April 6th 2022**By e-mail only:**

22/00747/OUT Land at Bicester Road, Kidlington (Allocation PR7a South)**1. Background**

I am writing on behalf of Stagecoach West to offer our observations and additional information regarding the development proposals on the southern of two land parcels that form allocation PR7a in the Cherwell Local Plan Part 1 Partial Review. (LPP1PR). The principle of development here is accordingly established, and with it, key development parameters that are set in policy.

Access Strategy

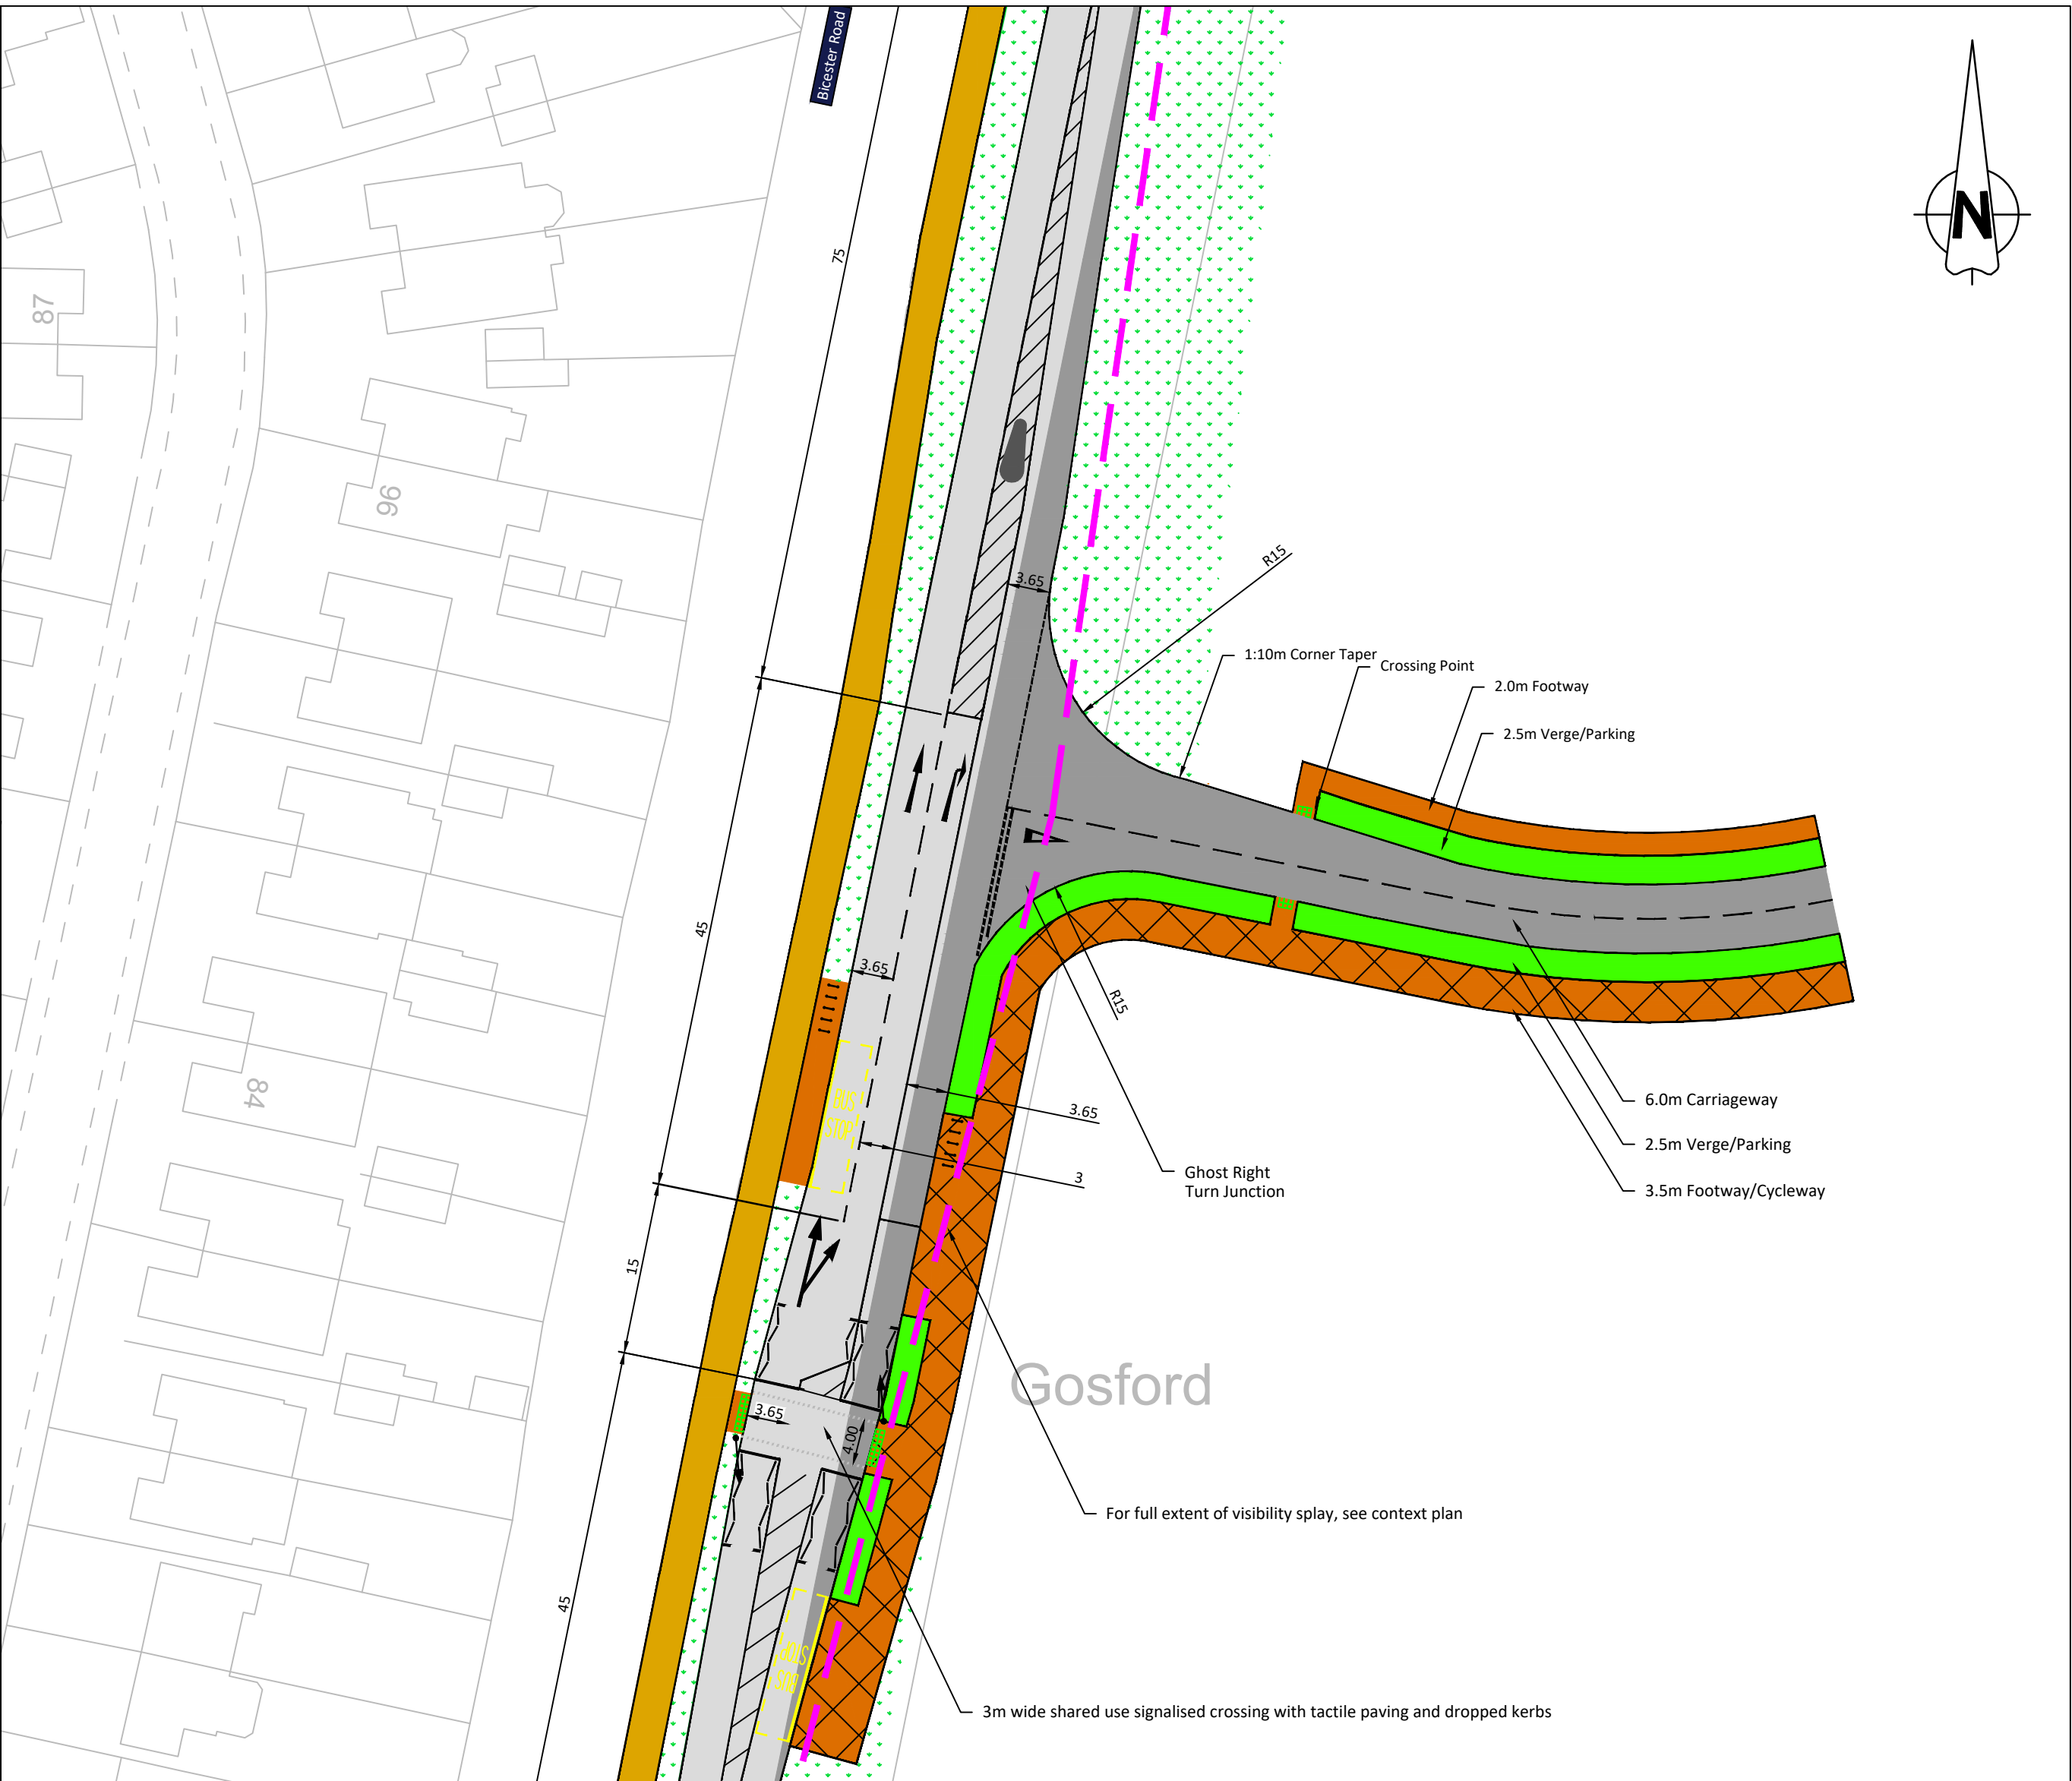
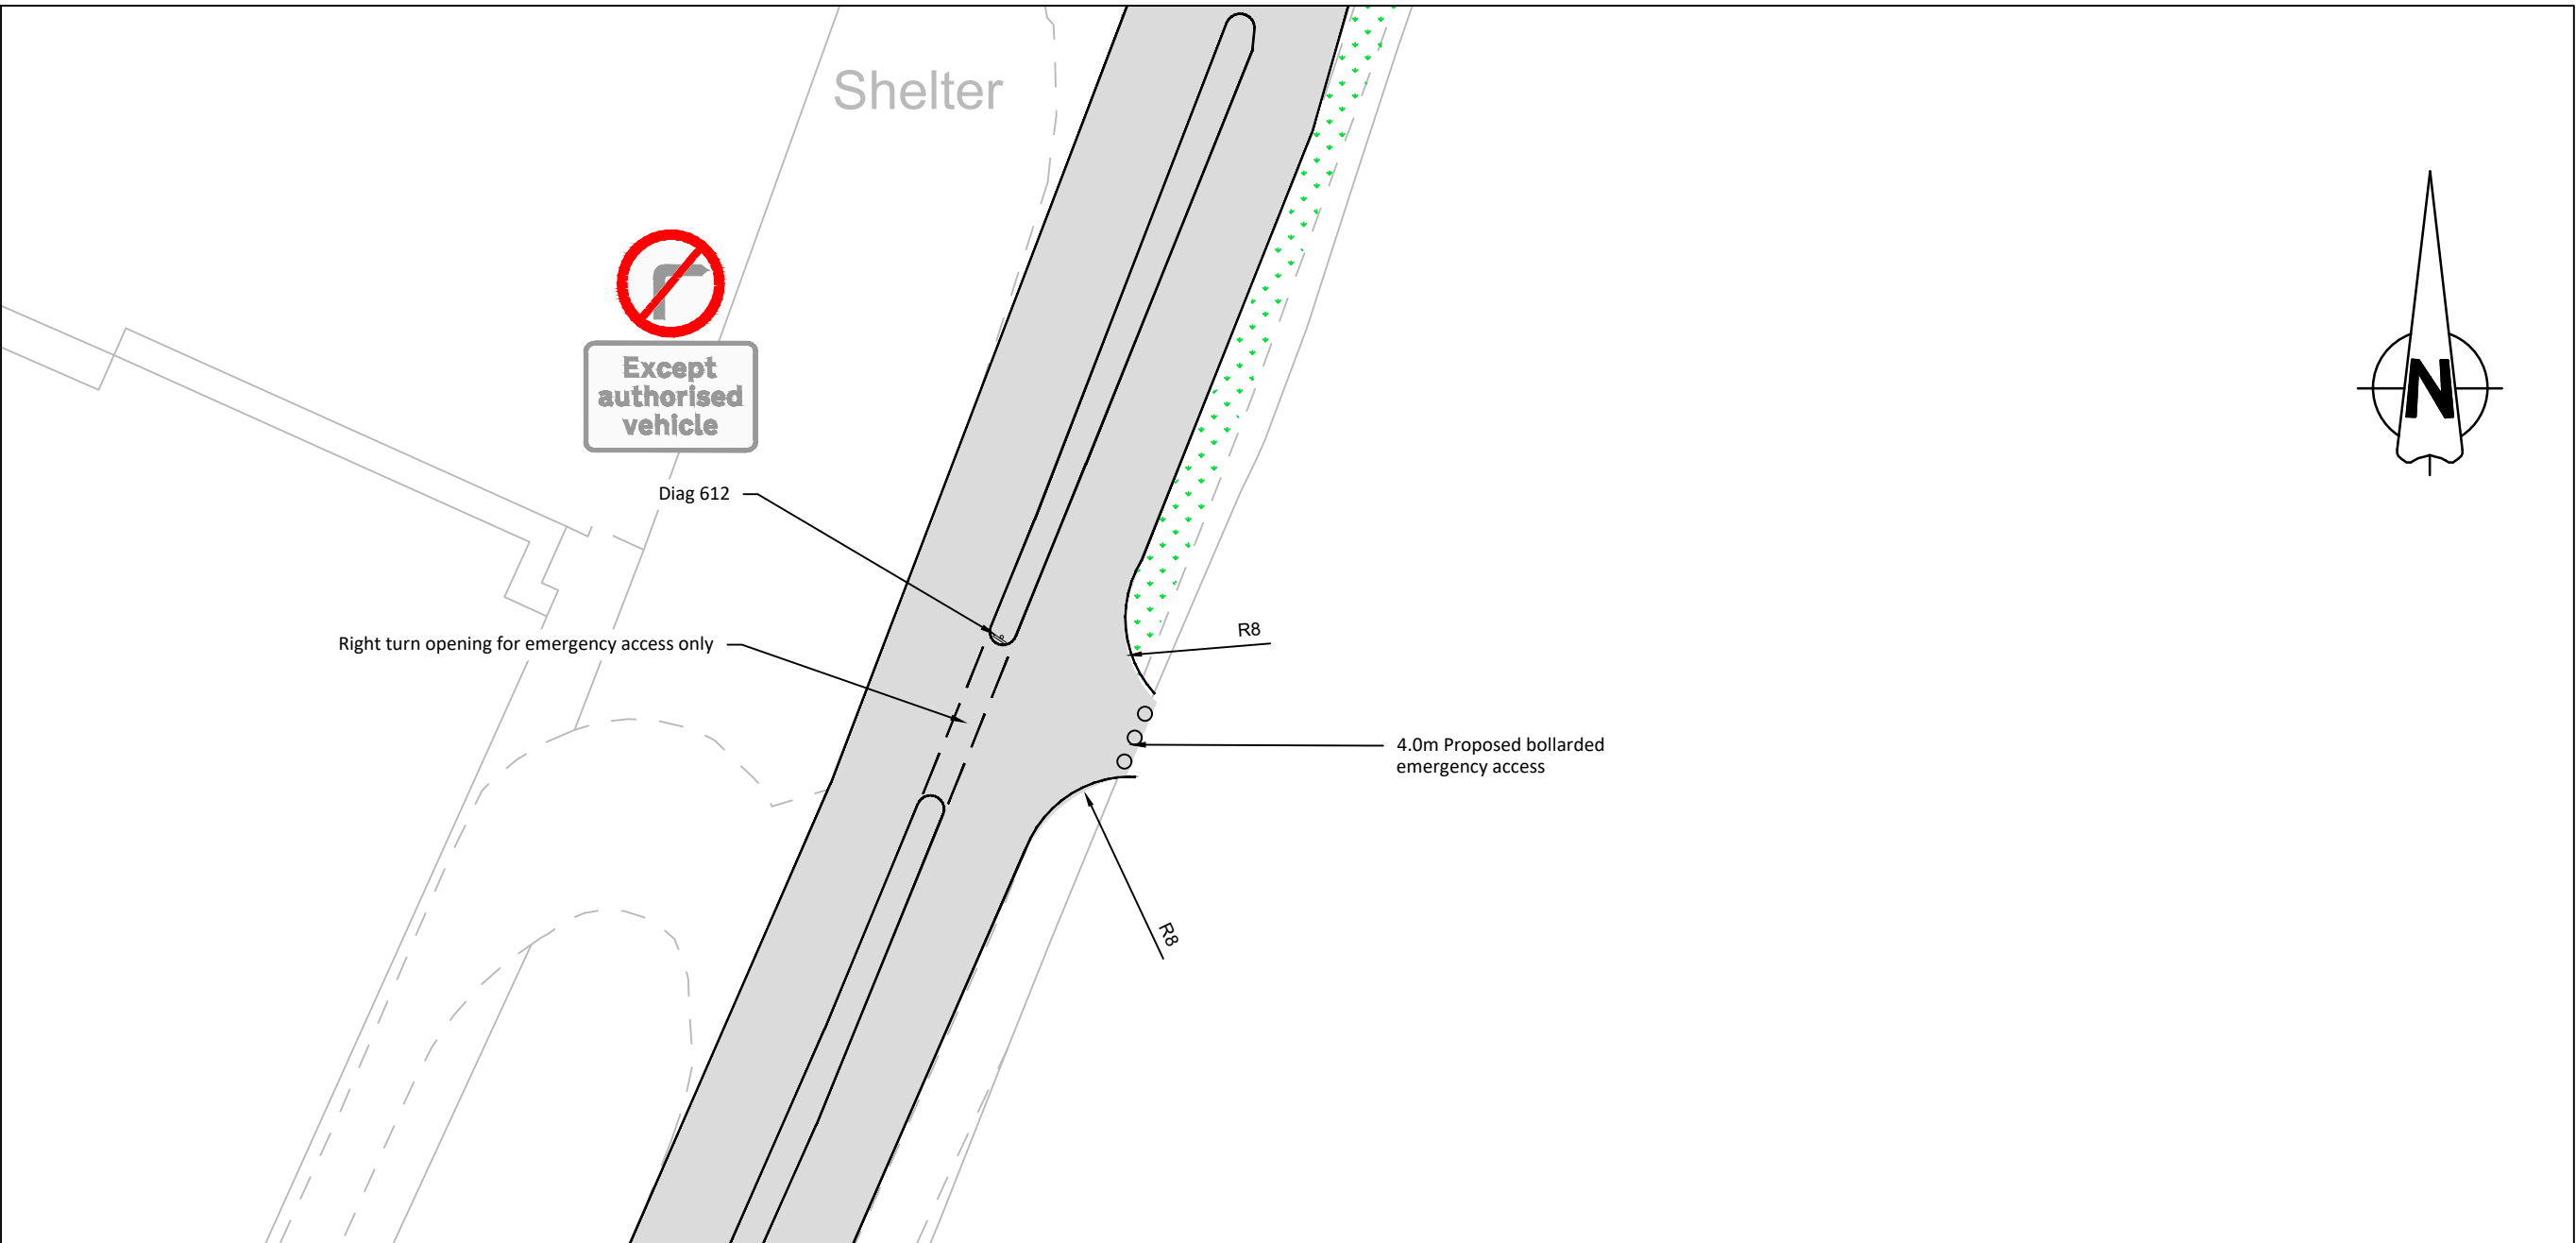
Bus stops on Bicester Road, near the Sainsbury's access at the southern end of the site, are marked on the Access Strategy, in a fairly broad brush way. There are no more stops until Gosford, some distance to the north, reflecting the fact that the existing urban edge of Kidlington at this point is impermeable and the adjoining development turns its back on this corridor.

We do not understand or recognise the "existing bus stops" marked at the back of Fairfax Centre, or on Cromwell Road in the Illustrative Development Framework. These do not exist on the ground.

The shared use cycle facility at the main vehicular access does not take a direct route across Bicester Road. The crossing facility does not appear to be able to accommodate a cycle within the central island, and there seems insufficient width for pedestrians and cycles to cross. It links to an existing shared use facility that is not on any clear desire line for either pedestrians or cycles. It may well be preferable to look at arrangements within the site and adjacent land that feed towards the north and north west, as the node at the existing Water Eaton Lane signals will be an important one for the allocation taken as a whole.

Appendix D in the TA sets out the proposed access arrangements. Especially since vehicular access is not a reserved matter, these drawings show a minimal level of detail. This is even more true of pedestrian and cycle access which we can only assume - by inference - is not reserved and will form a part of reserved matters applications. This is an unusual approach to take, if so. The material refers to pedestrian and cycle links associated with the southern point of connection in particular, which is that which most closely relates to pedestrian and cycle desire lines across the Bicester Road into Kidlington. No evidence of pedestrian or cycle provision is provided of any kind, despite this.
